Reference No:	2023/62/92783/W
Site Address:	56, Briarlyn Road, Birchencliffe, Huddersfield, HD3 3NP
Description:	Erection of front and rear dormers with raised decking and alterations
Recommending Officer:	Laura Yeadon

HOUSEHOLDER DELEGATED REPORT

Application Number	2023/92783
Location	56, Briarlyn Road, Birchencliffe, Huddersfield, HD3 3NP
Proposal	Erection of front and rear dormers with raised decking and alterations
Publicity end date	1 st November 2023
Number of representations received	None
Kirklees Local Plan Allocation/Designation	Unallocated land
Extension to Time (EoT)	EoT Date: Requested to 22.12.2023
Recommendation	Conditional Full Permission

Drawn	DRH
Date	August 2023
Scales	1:100 @ A3
Drawing No.	2382 - 0301 - P03

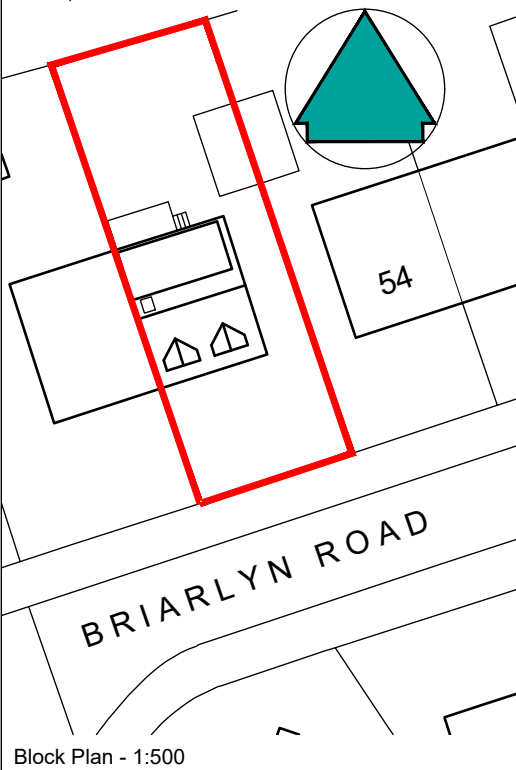
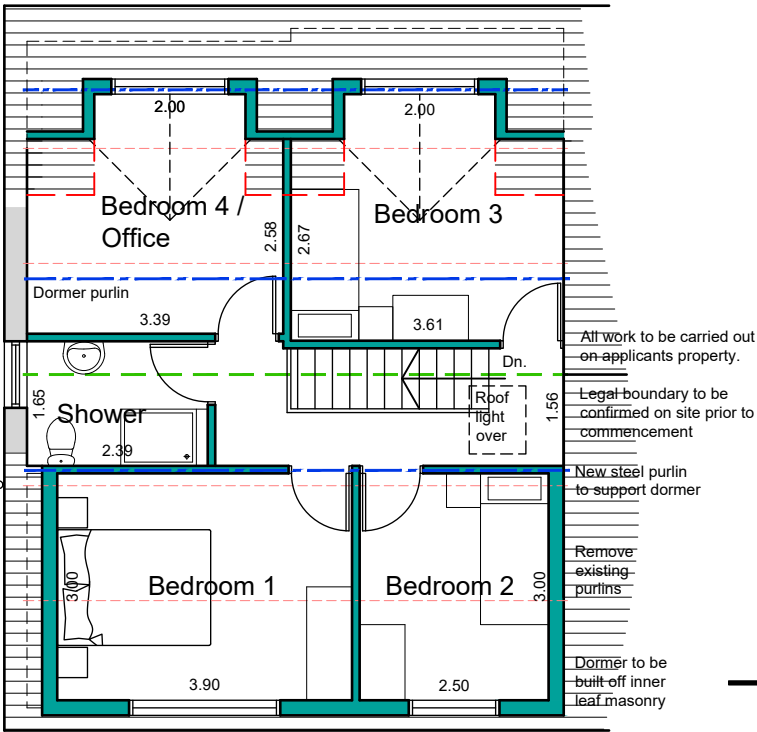
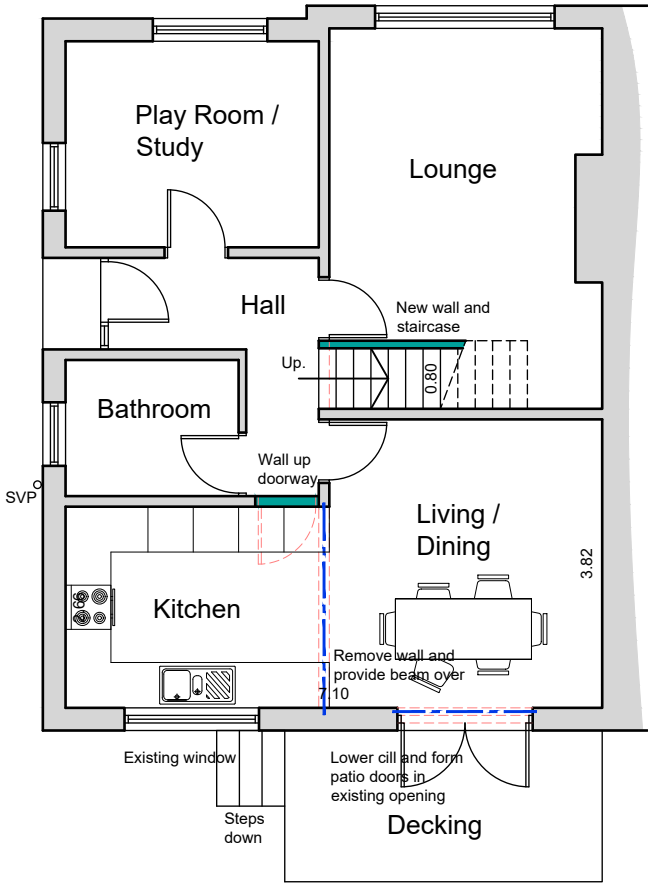
YES / NO	SUMMARY
Negotiations/Amendments during course of application	Yes	It was requested that the single dormer to the front elevation was either removed from the scheme or replaced with roof lights or two smaller dormers finished in grey tiles/cladding – amended plans were received on 14 th December 2023
Parish/Town Council comments sought	N/A	
Planning History	No

The initially proposed single front dormer has been omitted from the original scheme and replaced with two smaller dormers. The dormers are of identical size and would be a width of 2 metres each, set in from the boundaries of the property, set up from the gutter line by 1 metre and set down from the roof ridge by 0.2 metres. It is proposed that the dormers would be dark grey tiled/cladding.

The proposed rear dormer would also be a width of 6.8 metres, set in from the side elevation of the property by 0.6 metres and in from the shared boundary with the attached property by 0.3 metres. The dormer would be set up from the gutter line by 0.5 metres and set down from the roof ridge by 0.7 metres. It is proposed that the dormer would be dark grey tiled or clad.

It is proposed that decking would be installed to the rear of the property. The area of decking would be part width of the rear elevation at 4 metres and would project 2 metres from the rear elevation of the property at a height of 0.8 metres.

It is proposed that the window to the existing bedroom 1 would be removed and replaced with patio doors. It is also proposed that the fencing on the shared boundary adjacent to the proposed decking would be raised from 1.4 metres to 2.5 metres.

3. The terrace shall not be brought into use until the fence measuring 1.8 metres in height from the floor level of the terrace on the shared boundary with No. 54 Briarlyn Road and 2 metres in projection from the rear elevation of the property has been installed. Notwithstanding the provisions of the Town and Country Planning (General Permitted Development) (England) Order 2015 as amended (or any Order revoking or re-enacting that Order) the fencing shall be thereafter retained.

4. Notwithstanding the submitted plans, the pitched roof of the dormers to front shall be constructed from tiles which in all respects match those of the existing dwelling and shall be of a dark grey colour finish to the front and cheeks. The dormer to rear shall be of a dark grey colour finish to the front and cheeks. The materials of construction and colour finishes approved by this condition shall be thereafter retained.
